27th July 2026

Application No: F/33/26/PL
Site Address: Hangar 1 Ford Circular Technology Park Ford Road Ford BN18 0XL
Description of works: Replacement of existing cladding, installation of new roller shutter doors, roof alterations including increase in eaves height and alterations to fenestration. This application is in CIL Zone 2 (Zero Rated) as other development.

Thank you for your internet representation made on 27th July 2026 which has been recorded as an objection with the comments as follows:

Proposed HANGAR 1 SOUTH ELEVATION

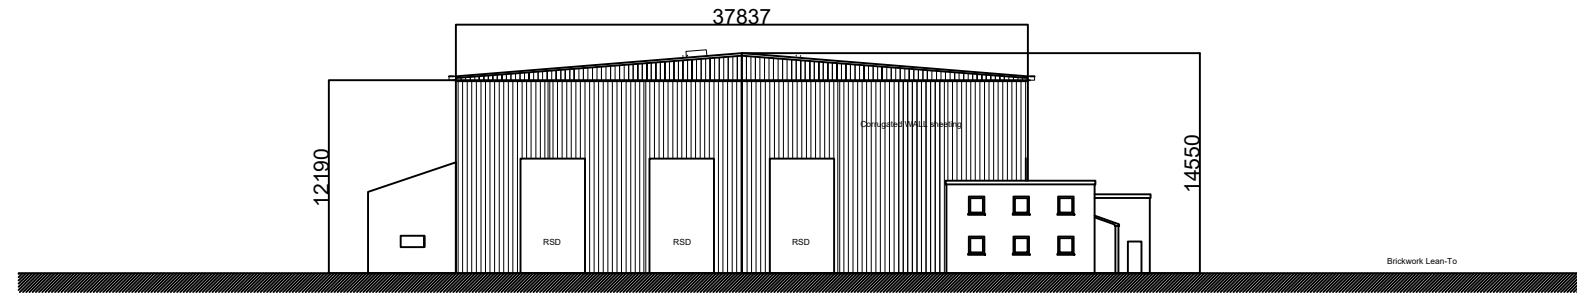
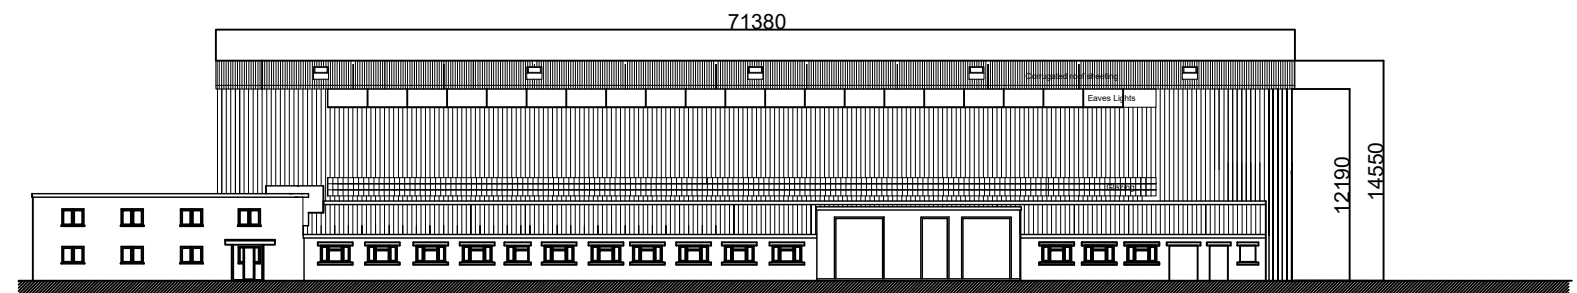
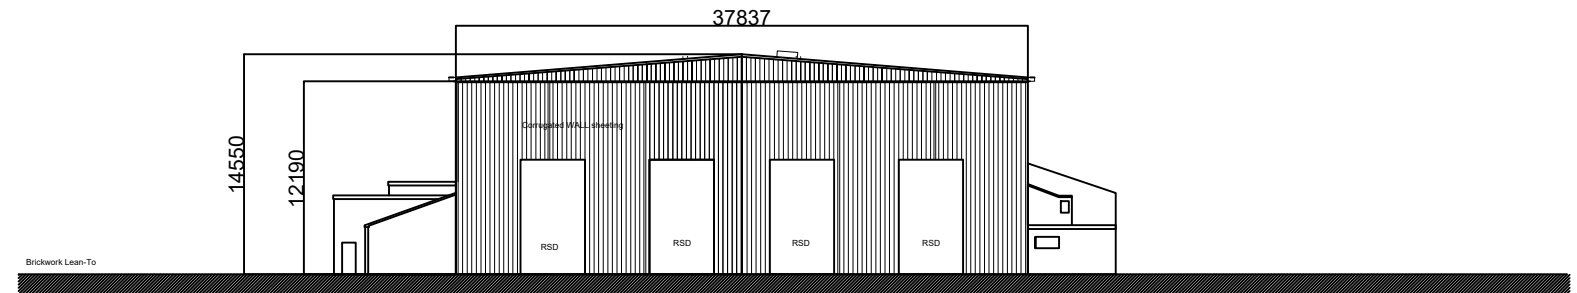
YPC is dismayed that the applicant has not provided existing and proposed elevations of the unit. YPC insist that fully annotated elevations of the existing build and proposed with heights are submitted. Such drawings would clearly highlight the significant increase in eaves and ridge height. An increase of at least 4.5m (14ft). This represents a significant change in appearance and character of the unit and should be dealt with as such in planning terms. Its height will dominate the skyline being significantly higher than any other building in the area.

A new unit with eaves heights of 12m+ as proposed will have a significant impact on the landscape and new adjacent houses at Fordham and those in Rodney Close. It will impact the Grade 1 buildings sightlines of St Mary's Church Yapton and the South Downs. The It will dominate and significantly adversely impact the landscape where all other industrial units in the area only stand at 5m maximum unlike the proposed 12m+.
